**APPLICATION REFERENCE NO: 147270**

**PROPOSAL: PINS consultation on behalf of the Secretary of State for its opinion (a scoping Opinion) as to the information to be provided in an Environmental Statement – EN020034**

**LOCATION: North Humber to High Marnham**

## Figure 6-3. National and Local Landscape Character Areas

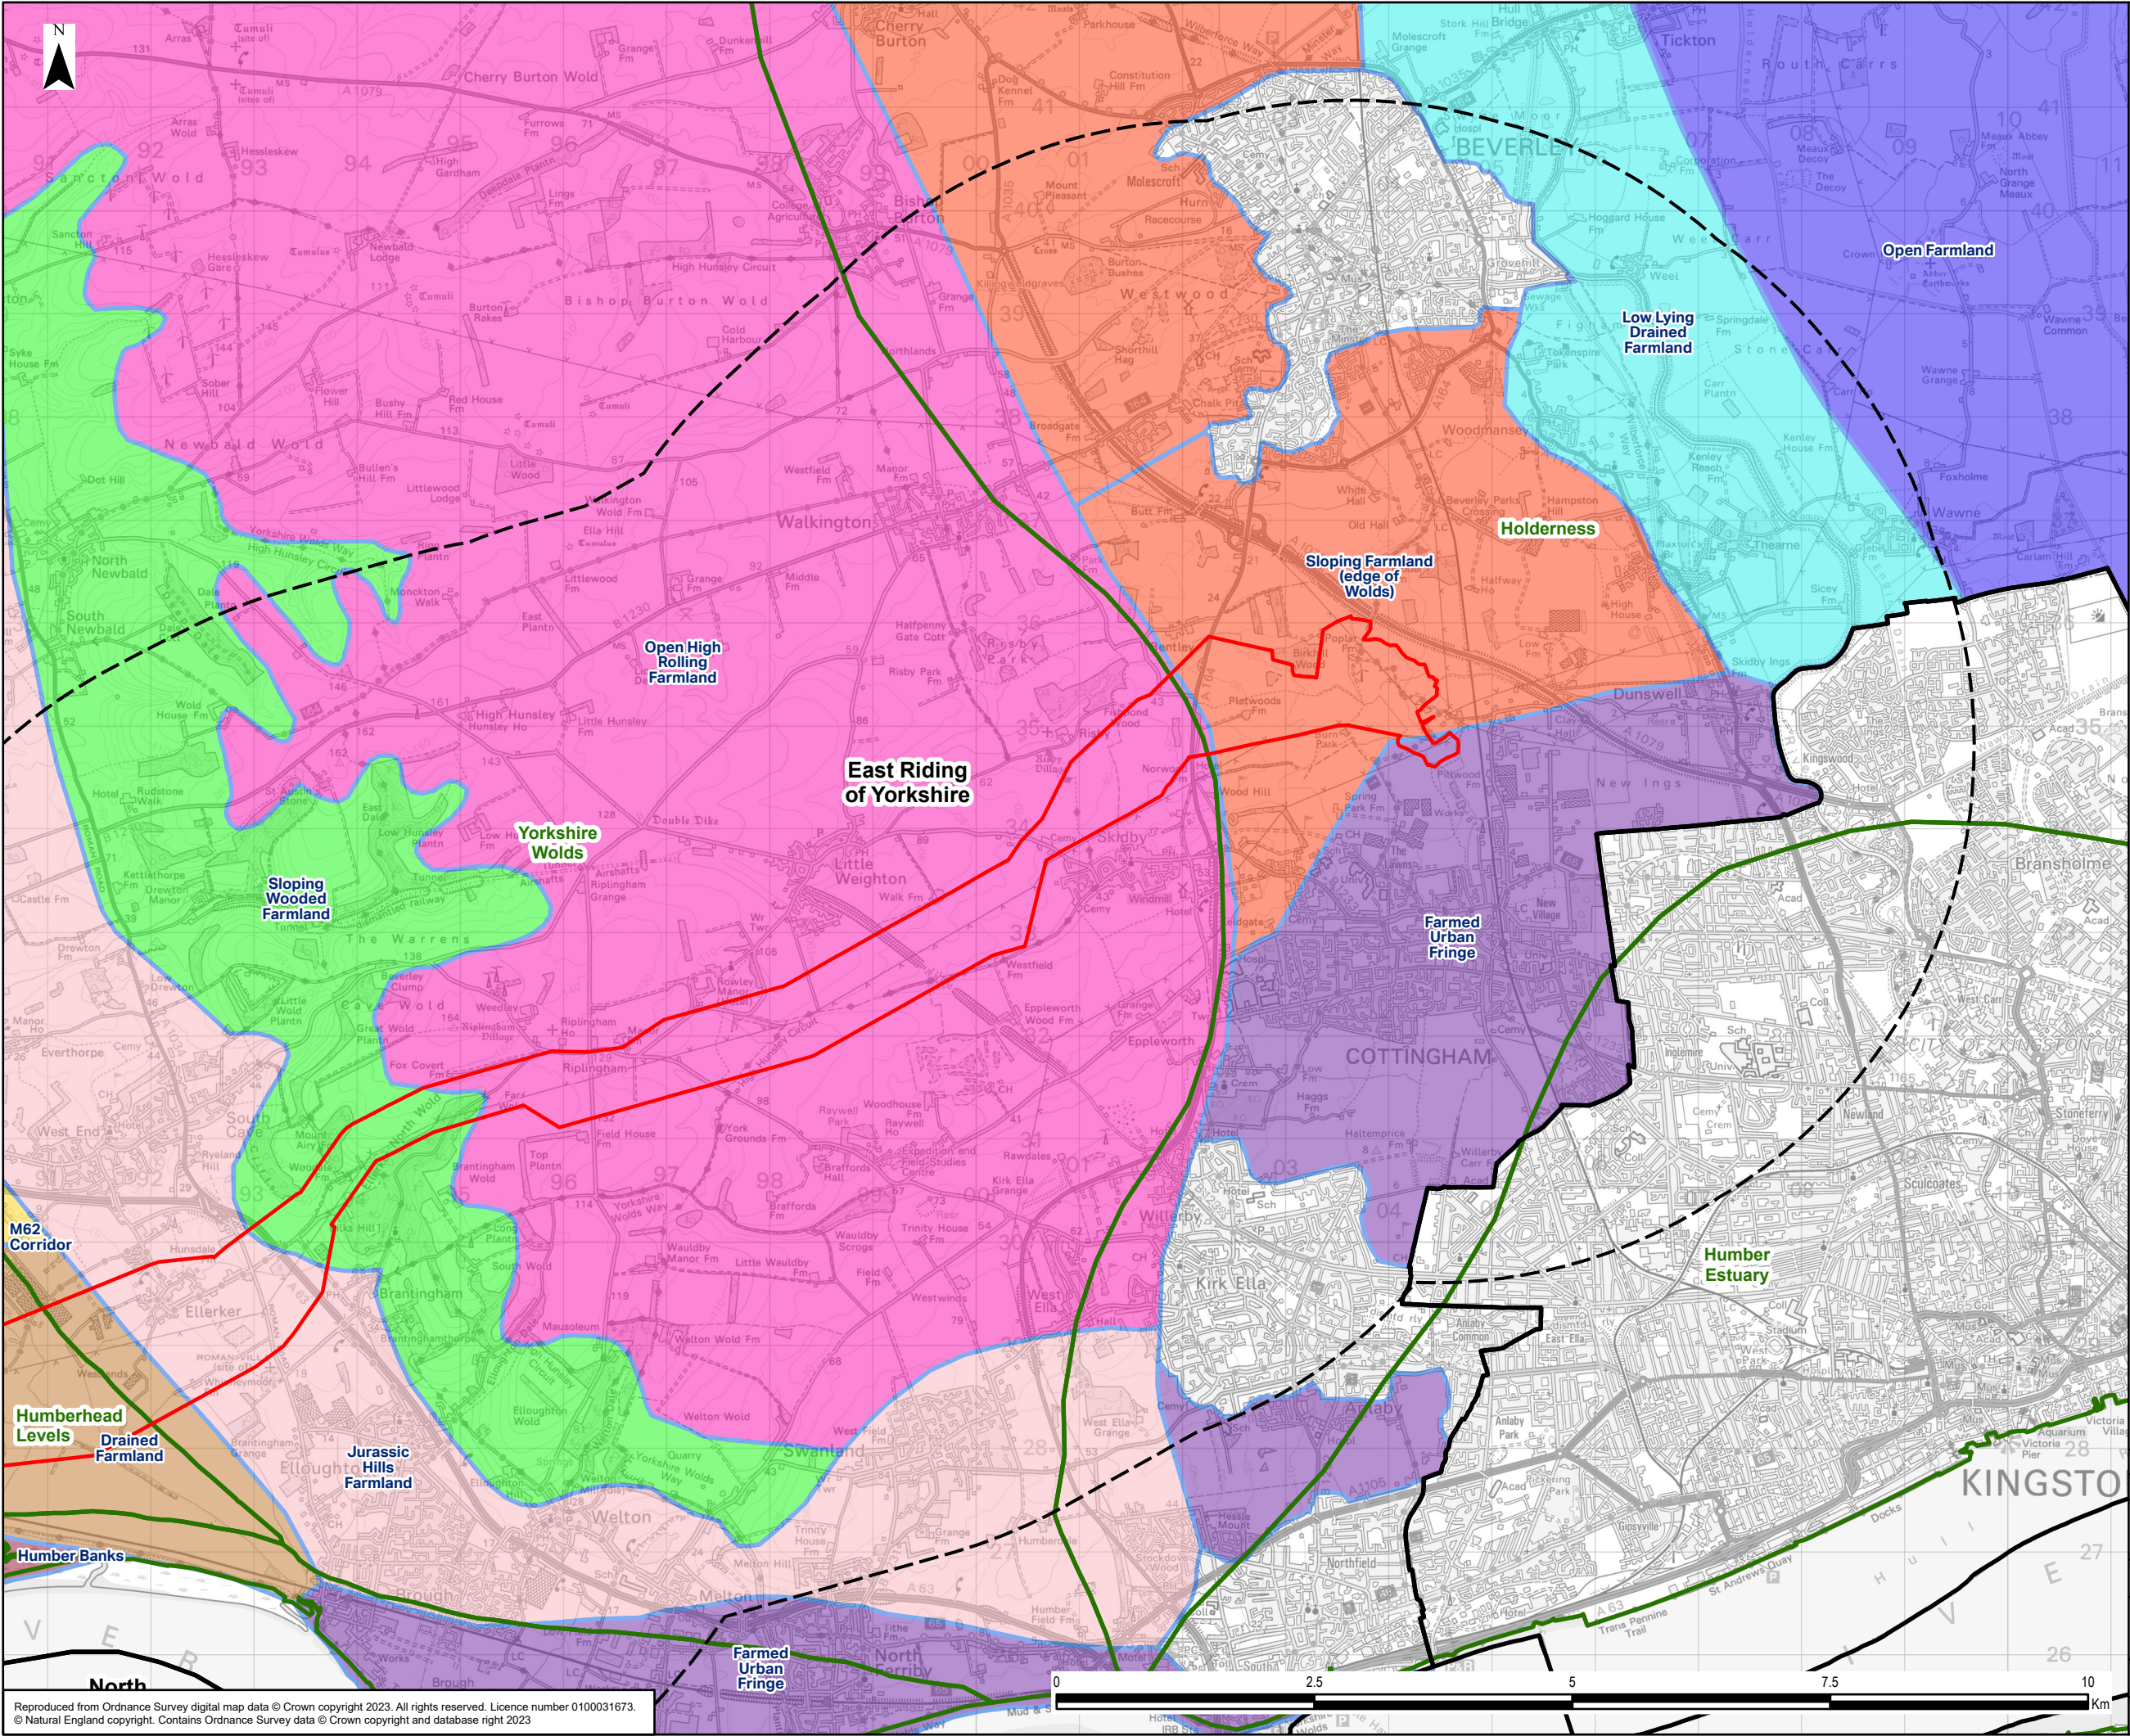
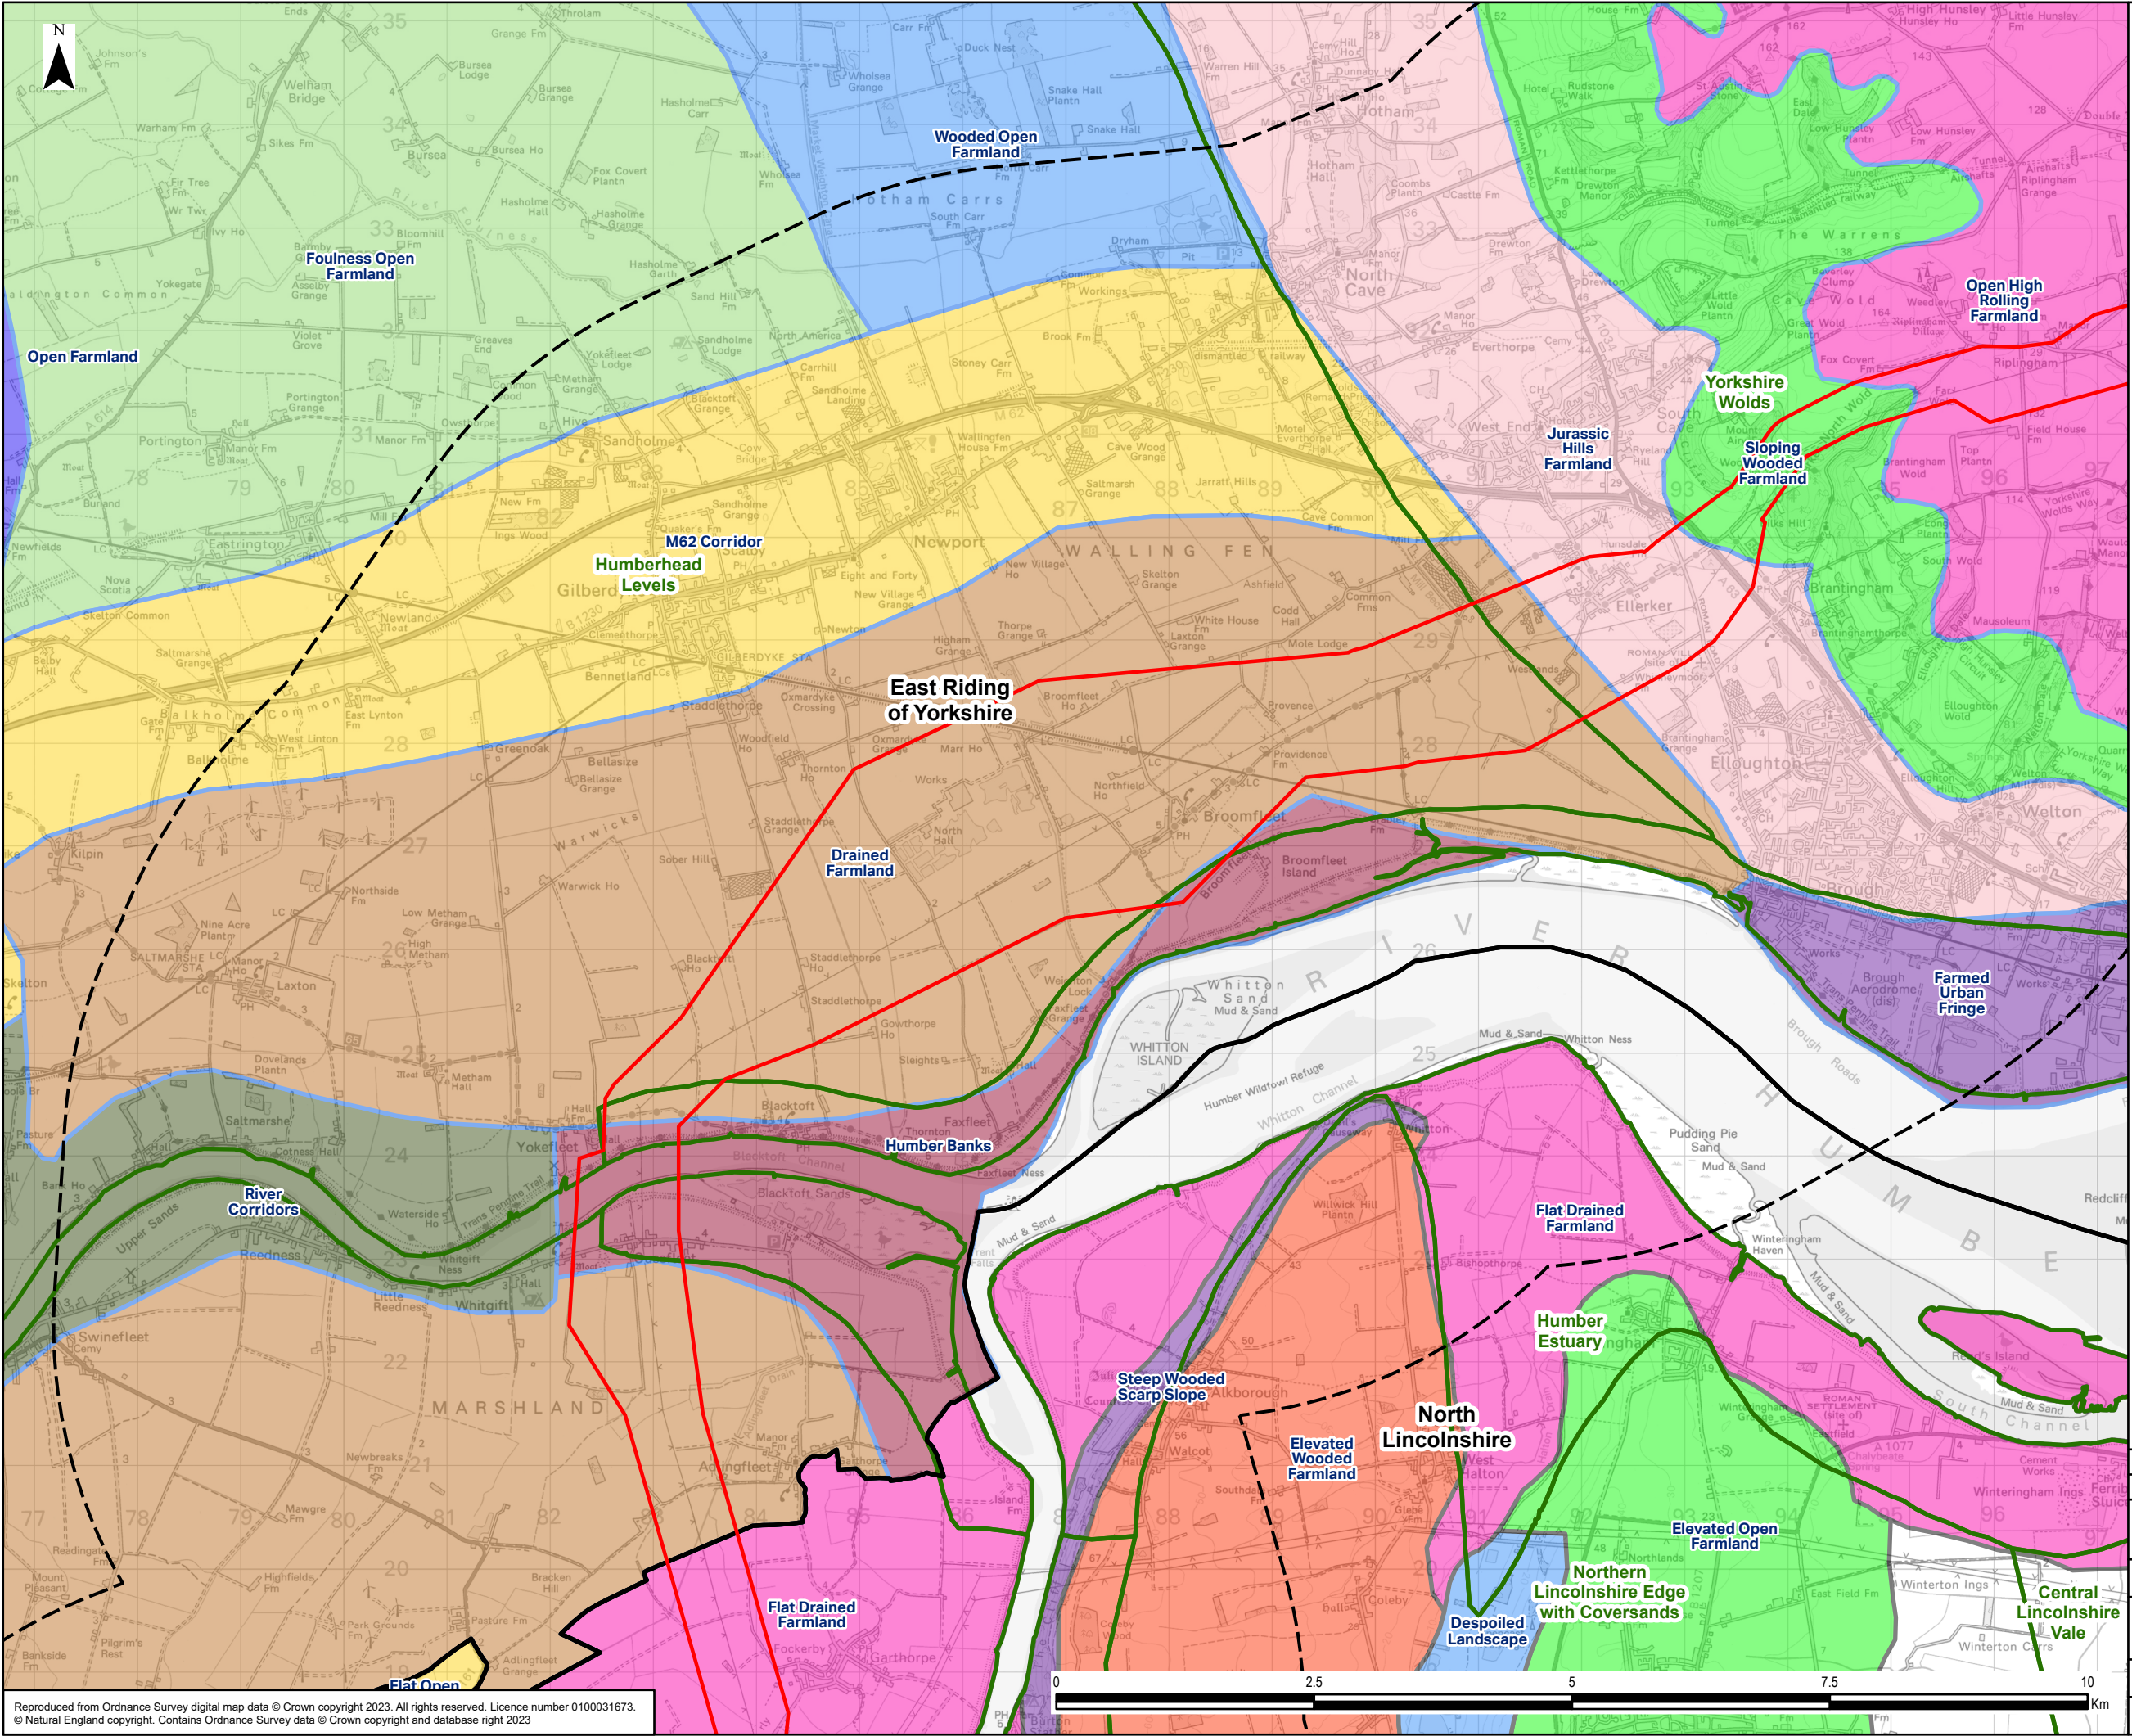
The approach to the LVIA not referencing National Character Areas (NCAs) and favouring Local Character Areas (LCA) is understood but the purpose of National Character Areas is to provide an overall picture of the character and appearance of an area at a larger scale. Given the nature and scale of the project, the lack of specific consideration to NCAs is concerning and it is the view of the Local Planning Authority that these should be **scoped in** to the final ES. The LVIA should also **scope in** the potential impacts (if any) on LCAs within West Lindsey. It is agreed that the Lincolnshire Wolds can be scoped out.

All relevant NCAs/LCAs within West Lindsey should be **scoped in** to the ES alongside consideration of all relevant development plan policies, including Neighbourhood Plans. This alongside Chapter 9 are the most important considerations to the Local Planning Authority and should be given an appropriate level of consideration.
